**Consultation Response from Alan Smith,
KC Waste Strategy (Refuse & Recycling)**

2025/92713 Rear of, 23 to 43, Moor Lane, Gomersal, Cleckheaton, BD19 4LF

Reserved matters application pursuant to outline permission 2023/92079 for erection of residential development of 10 dwellings, demolition of existing extension at 27 Moor Lane, widening of existing access and realignment of boundary walls and discharge of details reserved by conditions 4 (noise), 5 (BEMP), 6 (Arboricultural Impact Assessment), 7 (safety and security), 8 (landscape), 9 (LEDS)

Date Responded: 07/11/2025

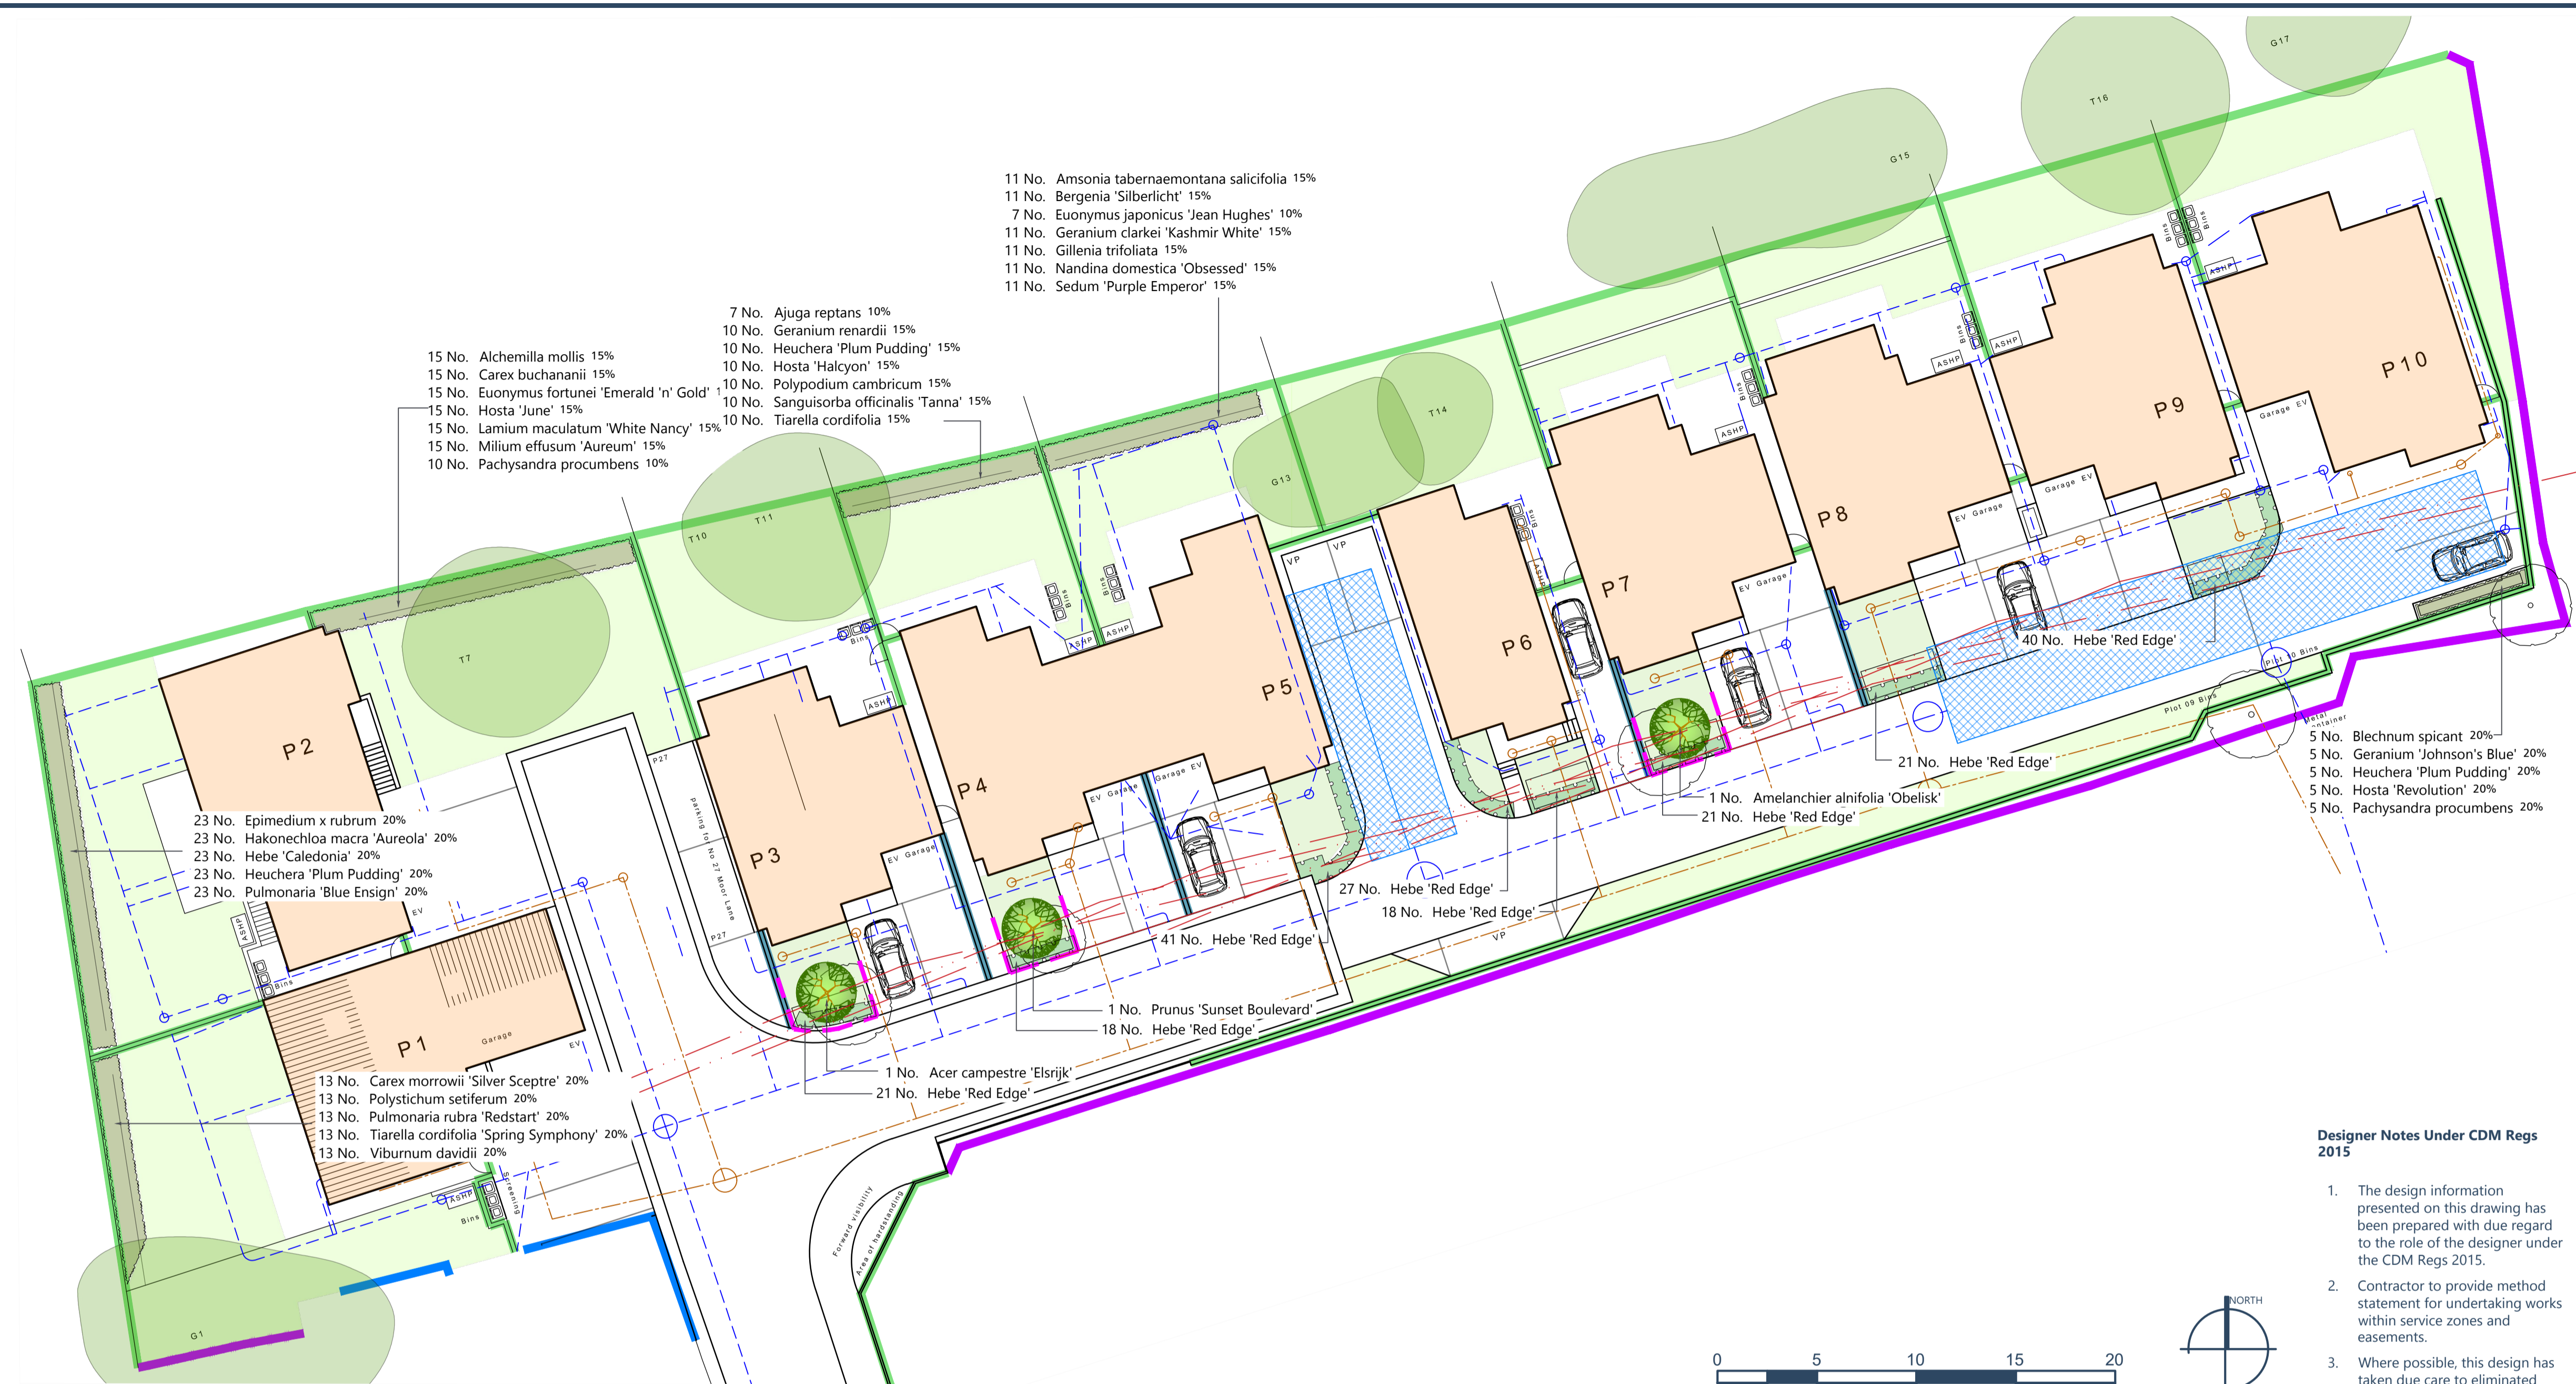
- Must be shown on a layout plan for all properties
- No gradients steeper than 1:12 or steps from storage area to BCP
- Located adjacent to an adoptable highway
- Solid surface required, resistant to constant wear and tear
- The maximum drag out distance from bin storage area to BCP is 25m (BS5906:2005)
- Temporary BCPs may be needed for early occupiers whilst site is being built (likely collection area would be adjacent to Moor Lane)
- Site specific comment
Plot 1 – bin storage area will need to be screened from the highway or moved so that the bins are not on view.

- The WCA will not enter:
 - Private drives
 - Roads not built to an adoptable standard
 - Active construction sites
- Road layout must:
 - Enable looped access (preferred over cul-de-sacs)
 - Where applicable, turning heads must be suitable for an 11.85m RCV
 - Turning areas must be made active to avoid them being used for additional parking
 - Where an RCV cannot enter the estate because of parked cars or manoeuvre in turning heads because of parked cars the BCP will move to the junction with **Moor Lane**
- Reversing distance for an RCV must not exceed 12m (WISH guidance)
